DRB Application No.: 07DRB-70125 (ASBP)

Project Name: NORTH ALBUQUERQUE  
ACRES, UNIT B

CITY OF ALBUQUERQUE  
PLANNING DEPARTMENT  
July 18, 2007  
DRB Comments

**RE: Gruet Winery/aspbp/revised comments**

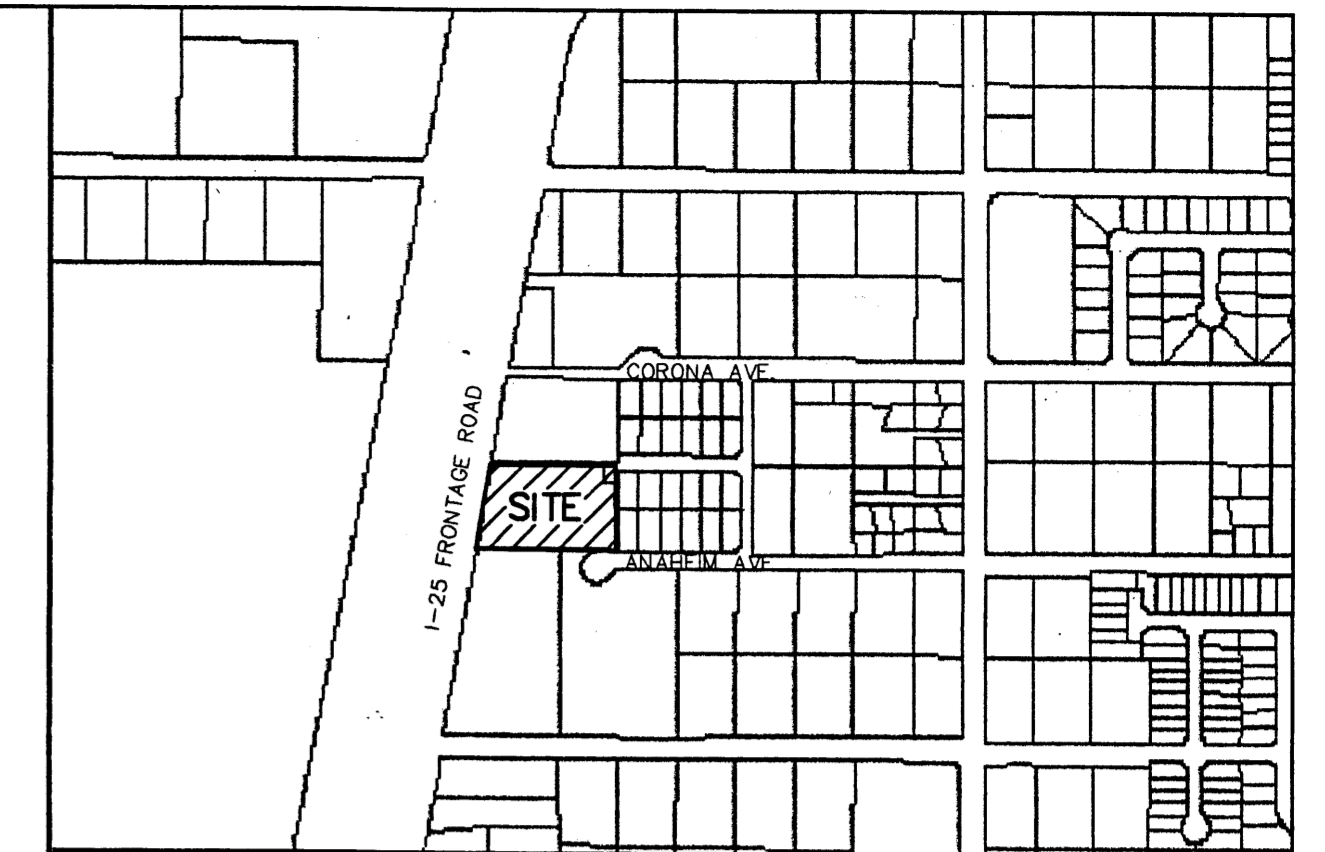
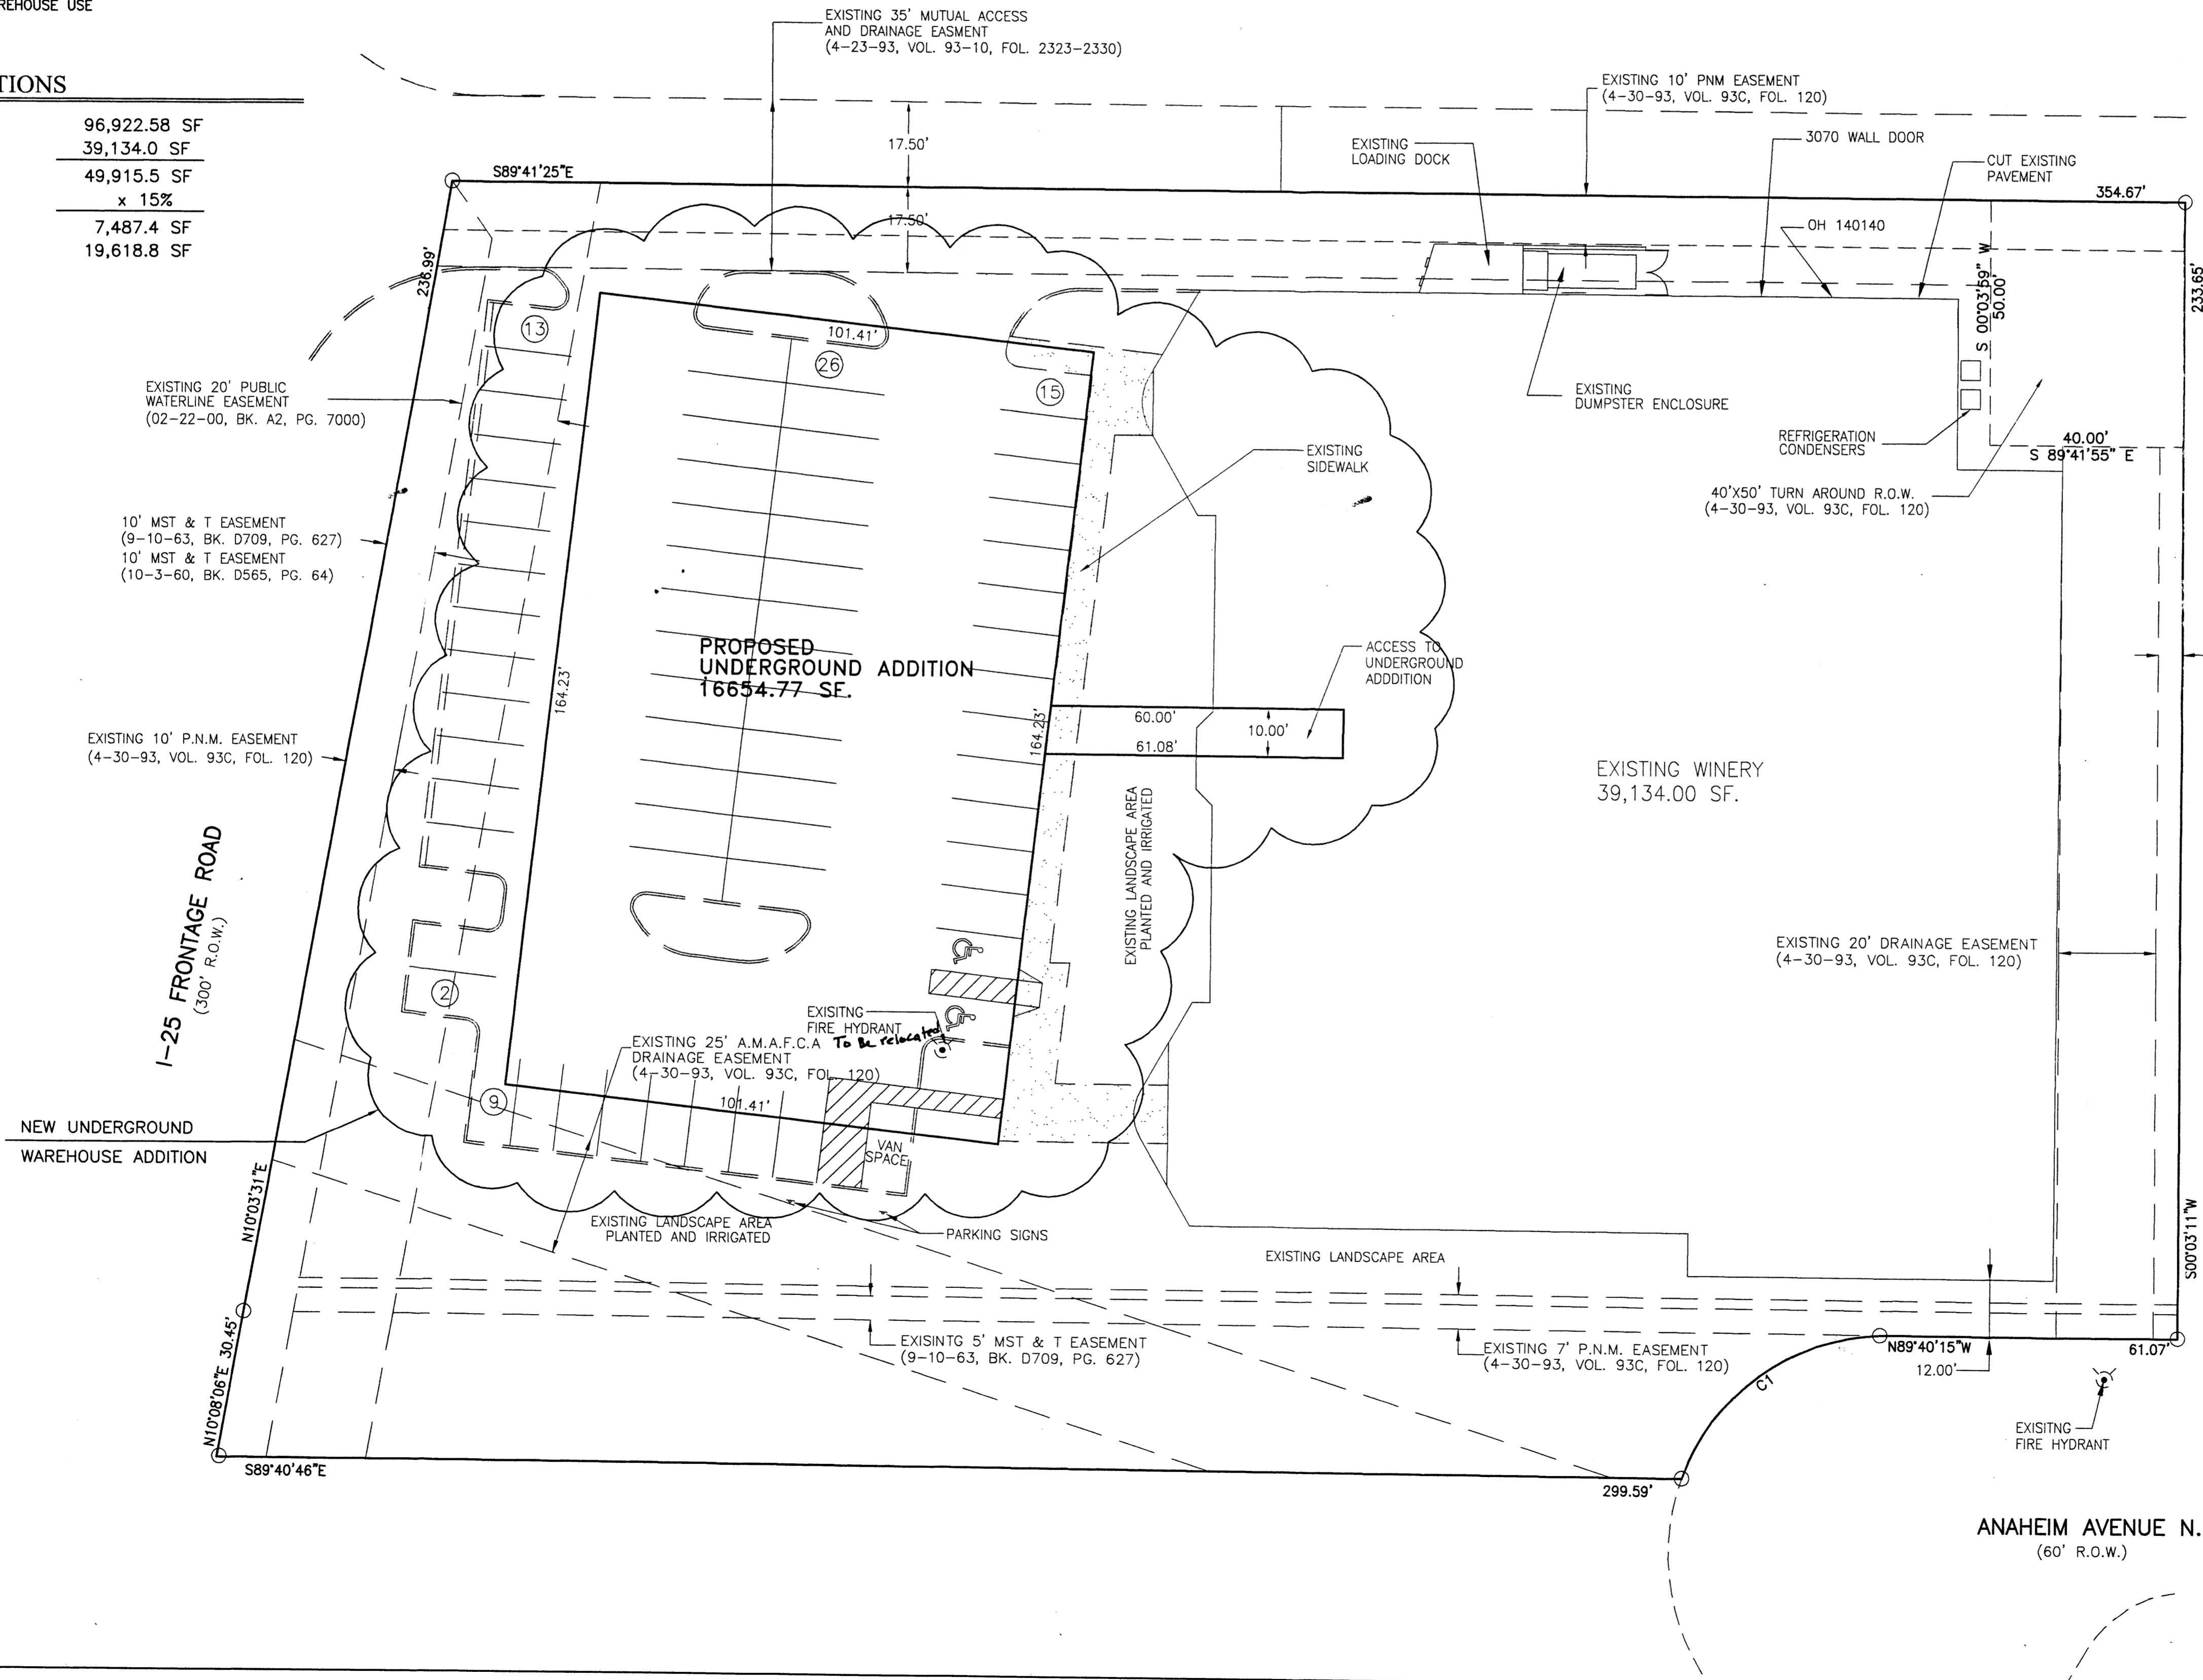
On the original SPBP plus the first amendment to that SPBP, 27, 520 square feet was listed as warehouse/mfg. On this second amendment, the designation was changed to warehouse only. Why the change in designation? If the designation changed, another amendment is required as well as a notarized statement from one of the principal owners attesting to that fact. This change will eliminate the requirement for 15 parking spaces. So it is a significant change.

The underground warehouse requires 9 spaces. Planning neglected to count a partial space as requiring a whole space. The new warehouse square footage requires 5 spaces not 4, for the same reason.

Assuming another amendment is submitted to change the previous designation of warehouse/mfg to warehouse only and a notarized statement is submitted at the same time, Planning will alter the number of required parking spaces to 39 or 2 more than listed on the latest amendment application. <sup>two</sup> Three of these spaces should be motorcycle spaces per the Zone Code.
